Your Ref: OWPC18504
Our Ref: WA/26/18/OUT 22-03-2018
Please ask for:
Mr J Baeza

Outline application with all matters reserved for 6 No detached houses with detached garages. This application is a Departure from the Development Plan.
Former Lanes End House Adjacent to West Walberton Lane & Arundel Lane Walberton

Former Lanes End - Six Six bedroom detached Houses with Garages Proposed Layout Scale 1:100 @ A3 (c) PJ Developments LTD 2018		REVISIONS		01
		MM/DD/YY	REMARKS	
	1	--/--/--	...	A
	2	--/--/--	...	
	3	--/--/--	...	
	4	--/--/--	...	
	5	--/--/--	...	
West Walberton Lane Proposal

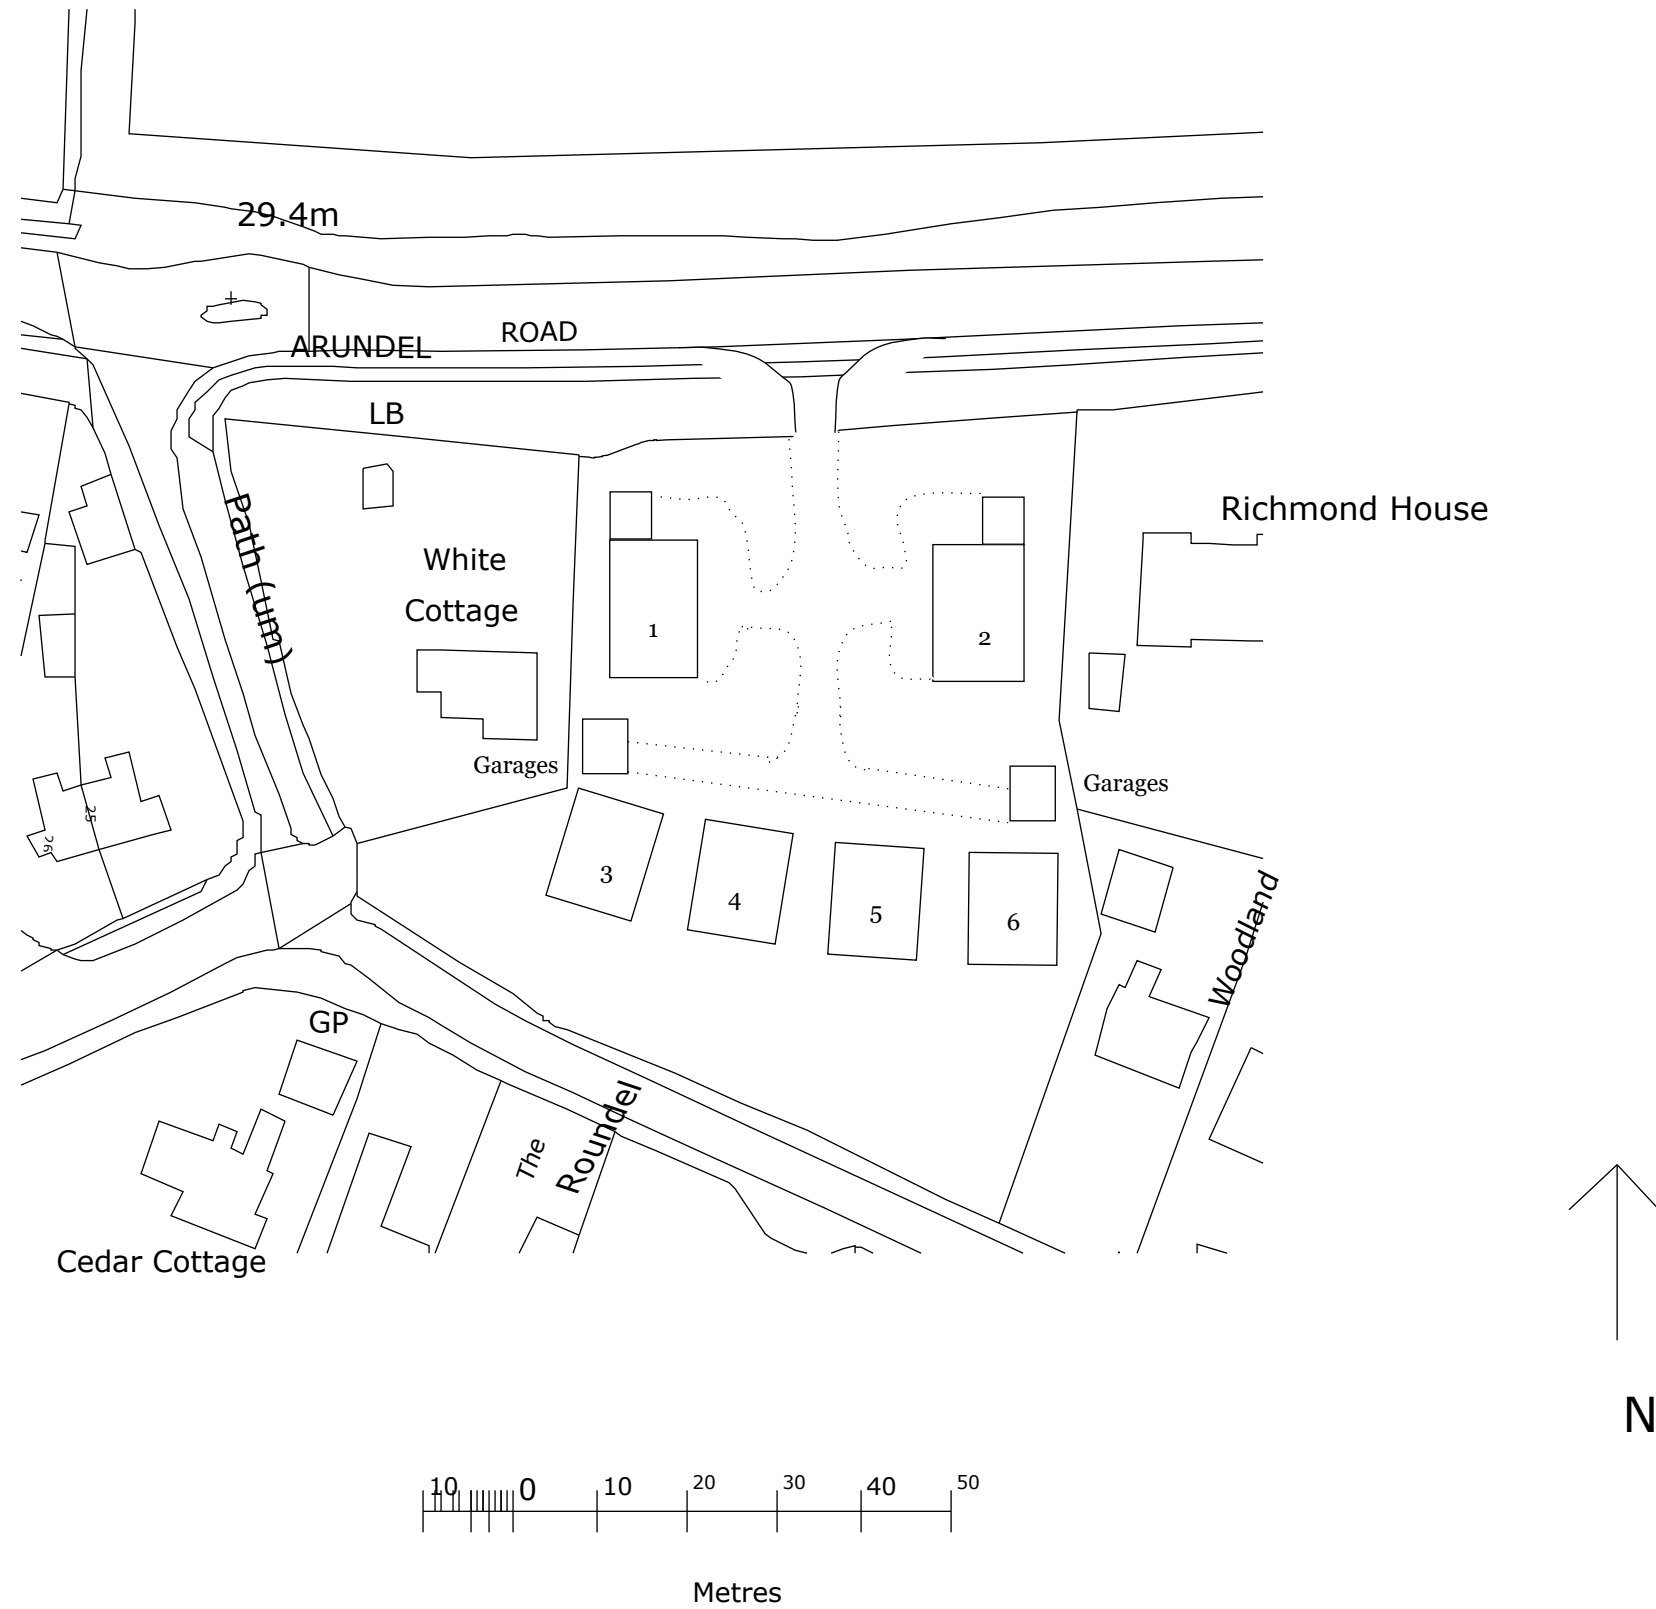
- 1) The four houses in a row to the south of the site appear to fall outside of the development plan area.*
- 2) The site is extremely cramped and there are no 3 story houses nearby so they will stand out and not be in keeping with the area. They will be very dominating and uncharacteristic of the general area.*
- 3) The plot sizes aren't going to be quite as large as suggested in the supporting statement given the area required for circulation and access. Units 1 and 2 in particular seem to have very small plots relative to the size of the house.*
- 4) There will be a complete loss of trees and homes to the nature.*
- 5) The main road in is very narrow and there is no pavement showing. There seems to be a lot of safety issues with this development. The access is too close to the roundabout.*
